An
Bord
Pleanála

Inspector's Report ABP-320327-24

Whether or not: (a) Structure No. 1: Gate Lodge A and Gate Lodge B; (b) Structure No. 2: semi-detached agricultural storage facility; (c) Structure No. 3: detached agricultural maintenance/storage facility; (d) Structure No. 4: electricity distribution building; (e) Structure No. 5: open fronted agricultural storage shed; (f) Structure No. 6: former agricultural building, now used to accommodate protected persons; (g) Structure No. 7 and Structure No. 8: pavillion and kitchen building; (h) Structure No. 10: former Belfry Building; (i) Structure No. 11: concrete paved area adjacent to structure no. 10 and 12; (j) Structure No. 12: accommodation block no. 1; (k) Structure No. 13: Art O'Neills building; (l) Structure No. 14: car park adjacent to the former Belfry Building; (m) Structure No. 15: large gravelled area to the north east of the holiday village; (n) Structure No. 16: accommodation block no. 2 and (o)

Kippure Lodge and Holiday Village,
Kippure Estate, Manor Kilbride,
Blessington, County Wicklow.

Structure 05

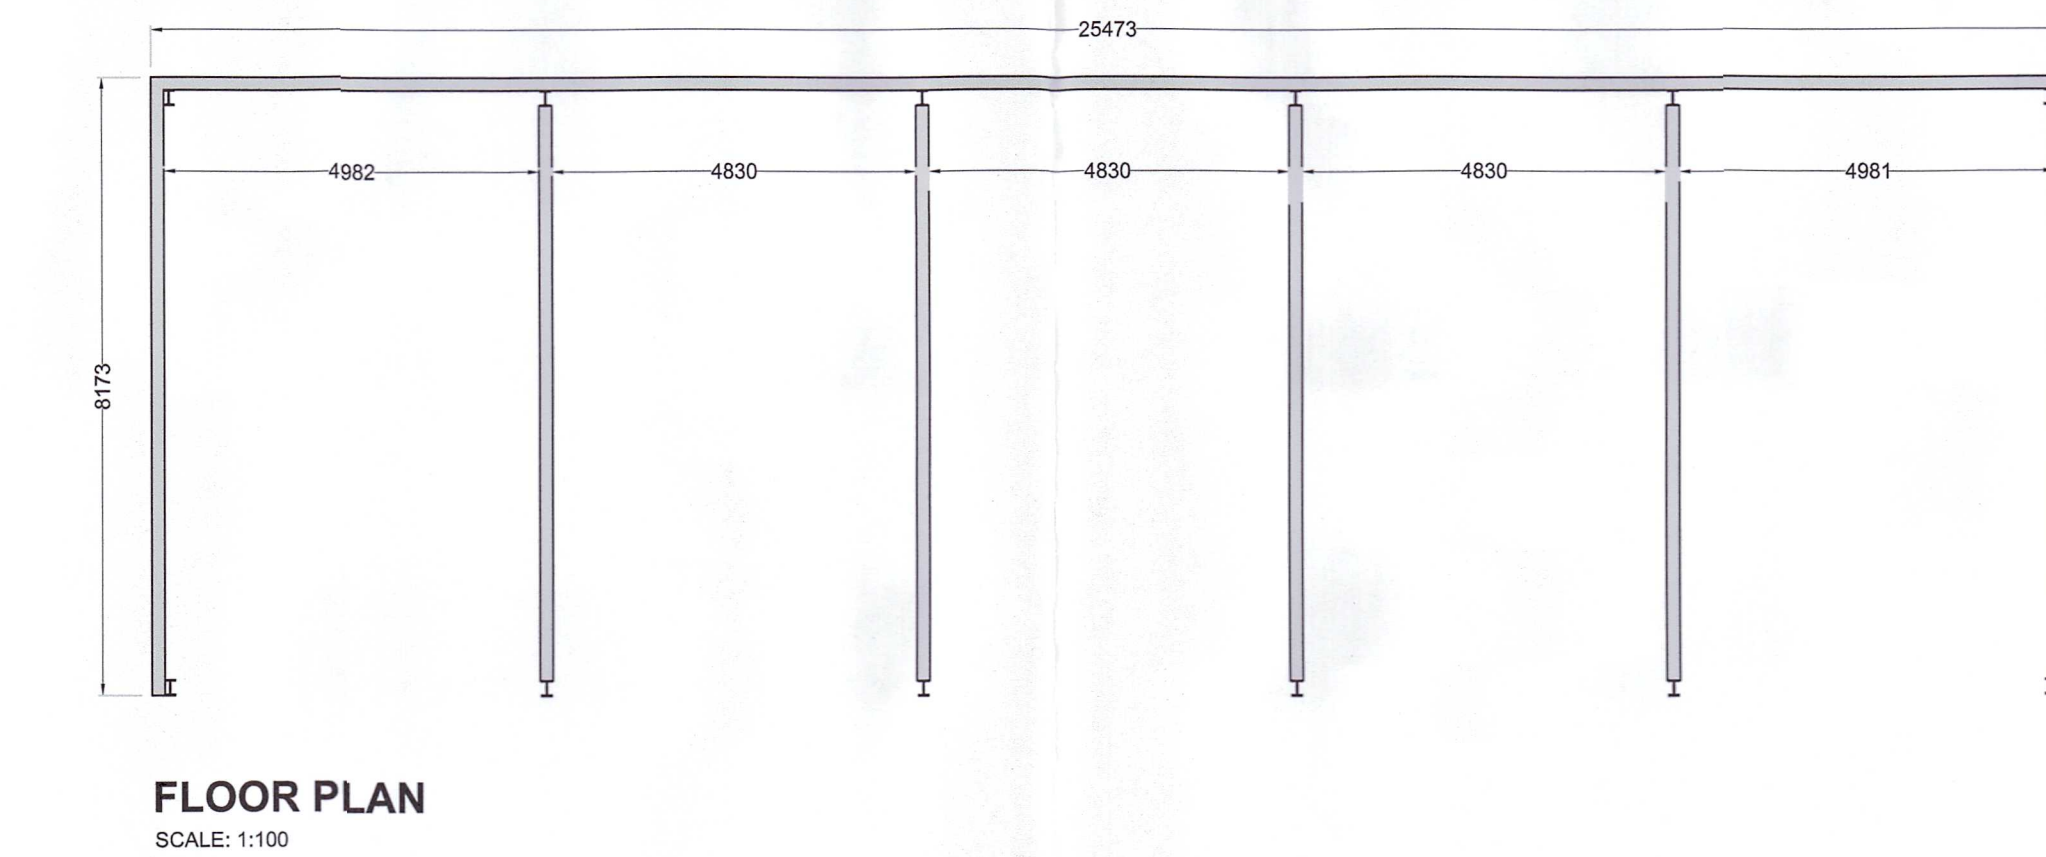
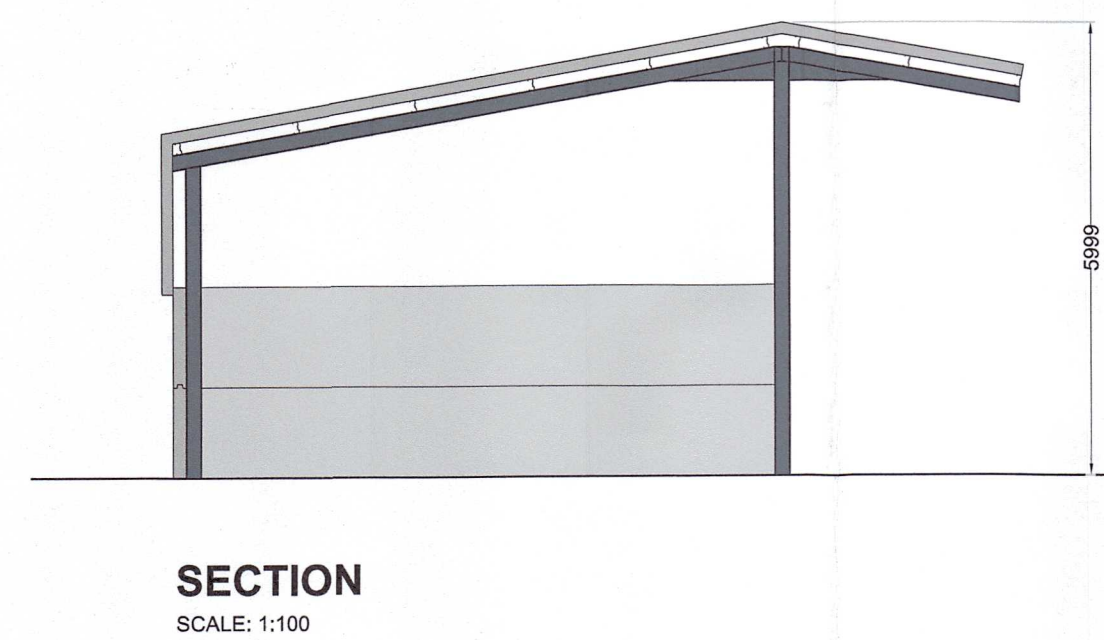
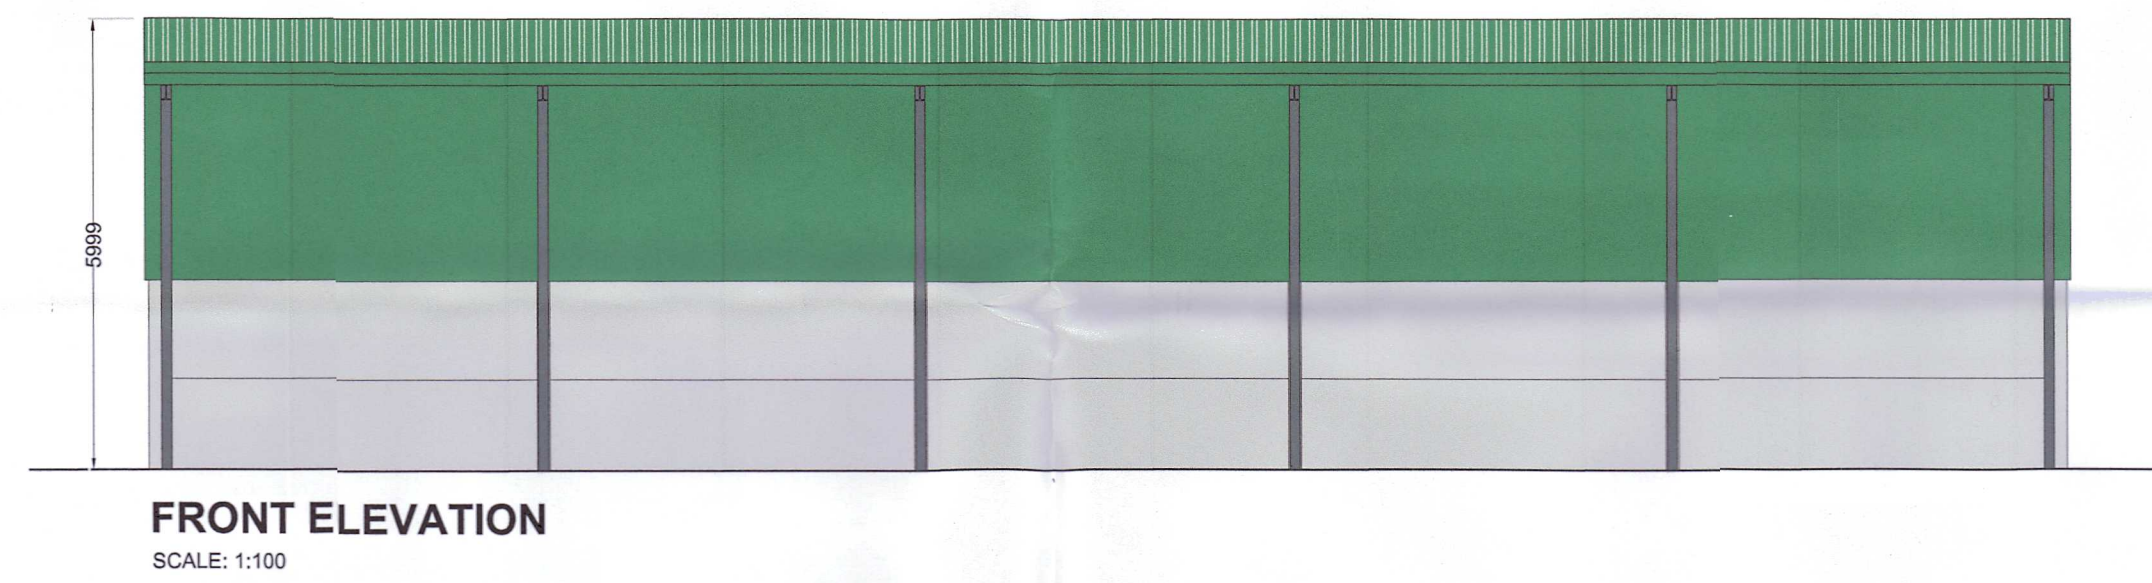
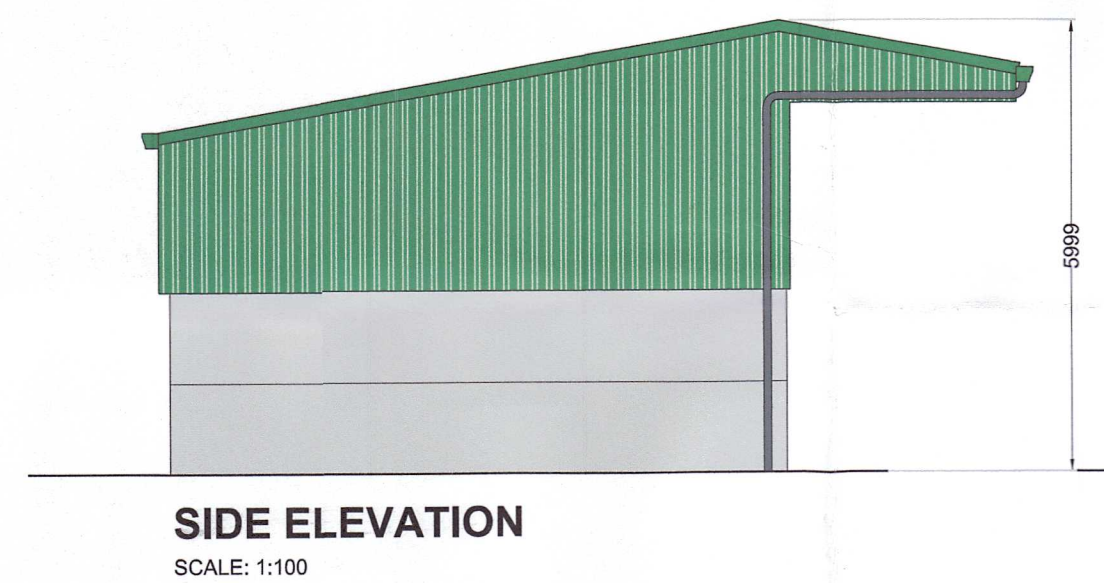
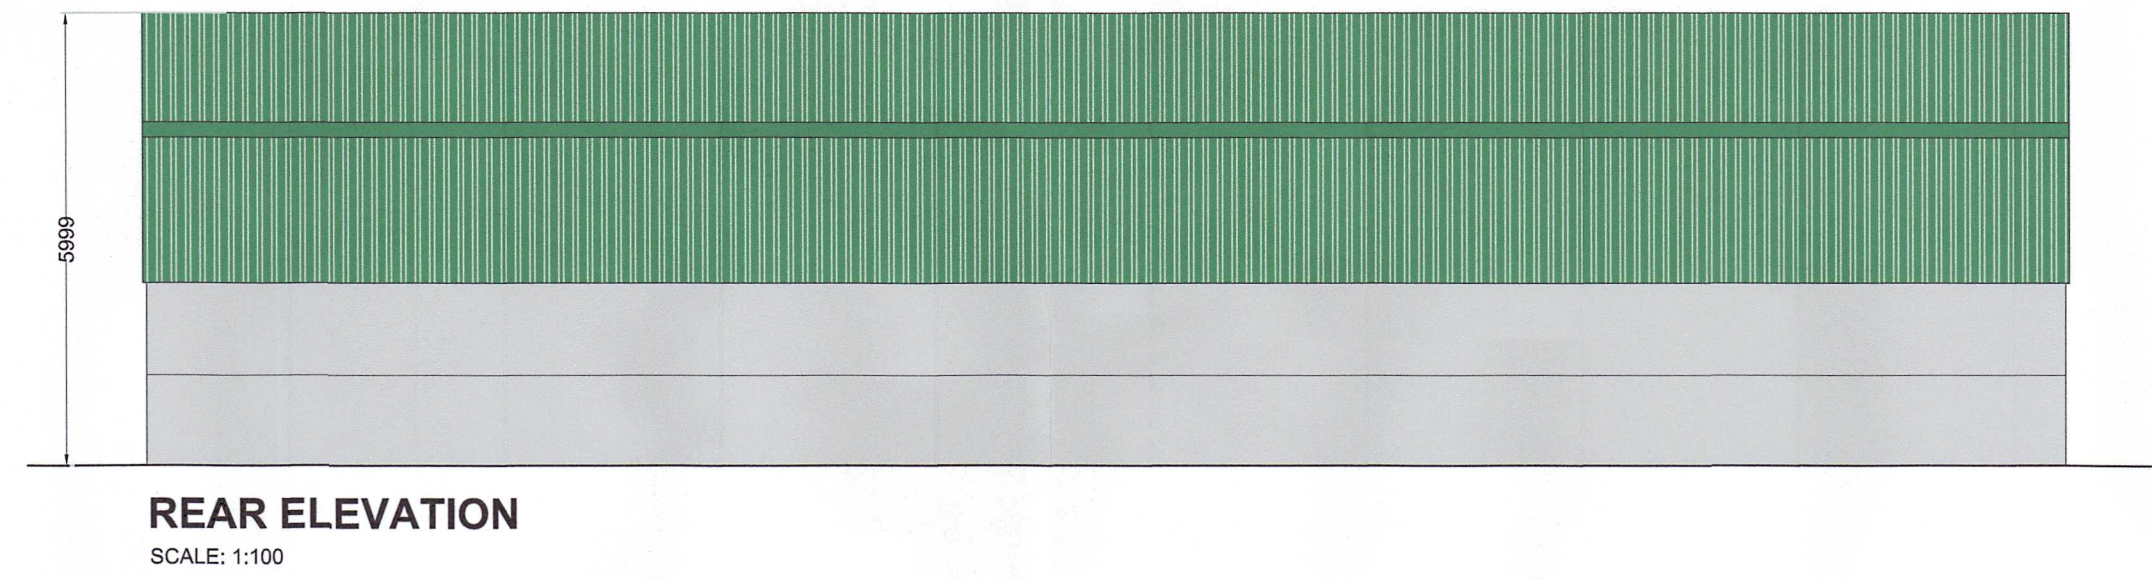
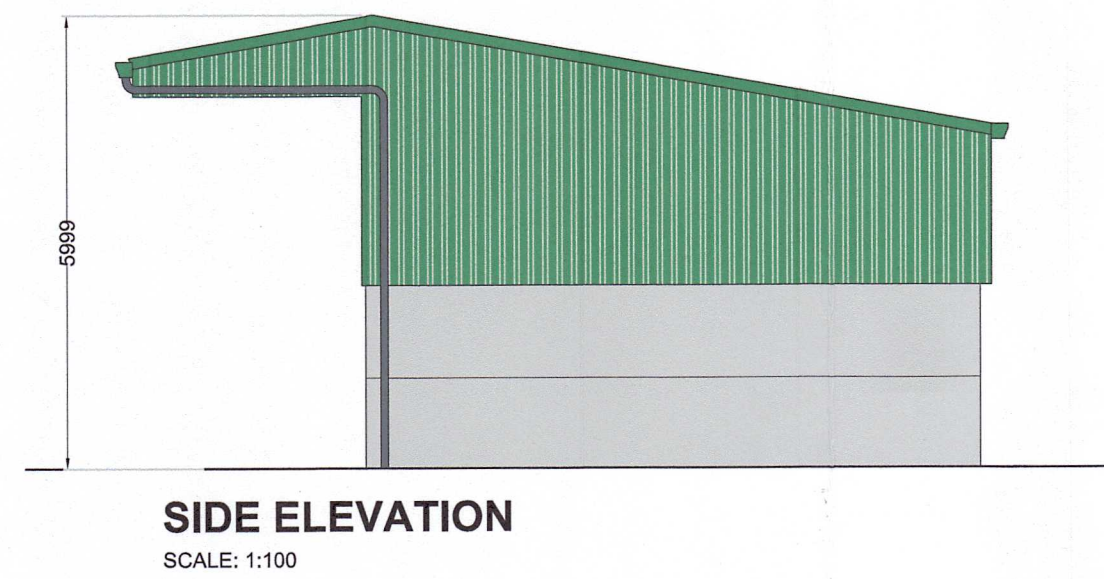
Class 9 of Part 3 of Schedule 2 provides an exemption for any store, barn, shed, glass house or other structure, having a gross floor area (GFA) not exceeding 300sqm. The structure has a GFA of 208sqm.

- The use can be considered as part of the overall maintenance of agricultural areas not dedicated to the Kippure Holiday Village.
- Structure no. 2 and 6 were completed prior to this structure and have an overall area of 1,134 sqm and would exceed the aggregate 900sqm limitation.
- The structure is in excess of 10m from the public road.
- The structure is not within 100m of any house.
- Metal sheeting on the structure is painted.

The structure would not come within the provisions of Class 9 and therefore is not exempted development.

Drawing file: 320327 Referral / PL-0708-01-KE Structure 07 & 08.pdf

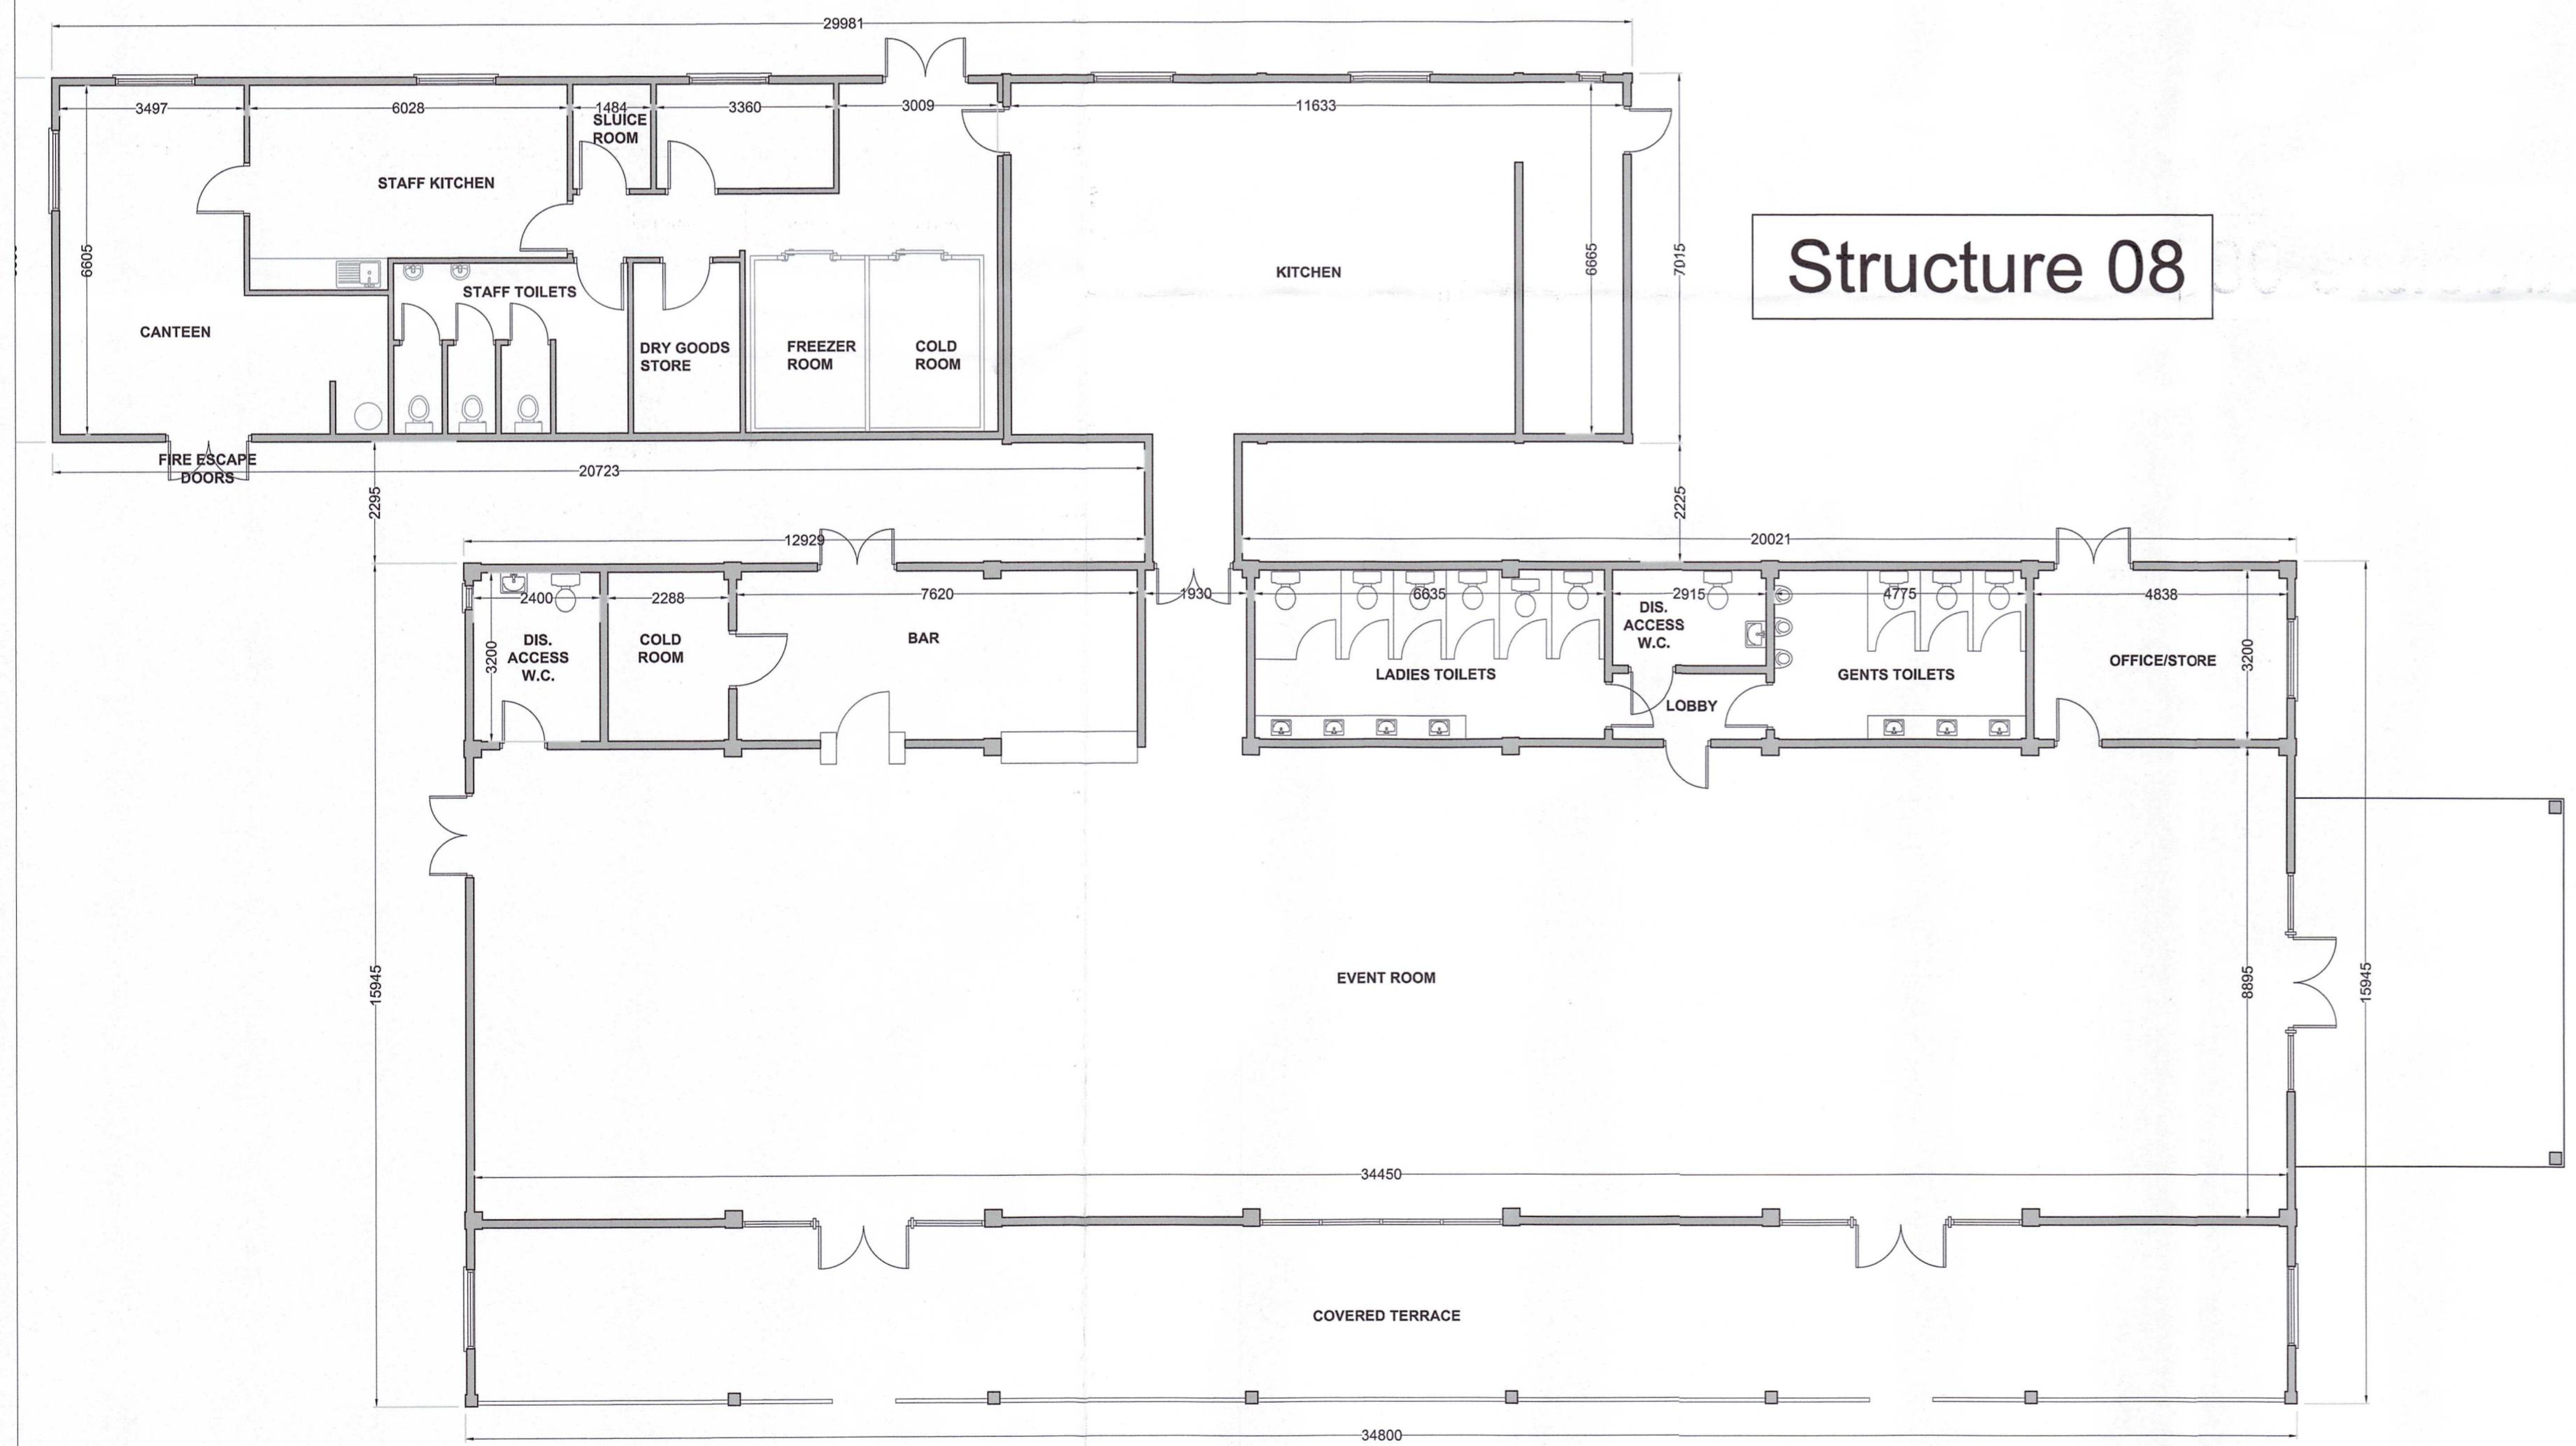
Structure No 7 and No. 8 are interlinked. The reference to this building being permitted under Reg. Ref. 17/1335 is incorrect as this decision was overturned on appeal, ABP 300834-18.

The structure comes within the meaning of works and would therefore come within the meaning of development as provided for in Section 3(1) of the PDA. There are no exemptions in the PDR that would apply to Structure No. 7 and Structure No. 8.

There are no other exemptions available for these structures. Therefore, these structures are development and are not exempted development.
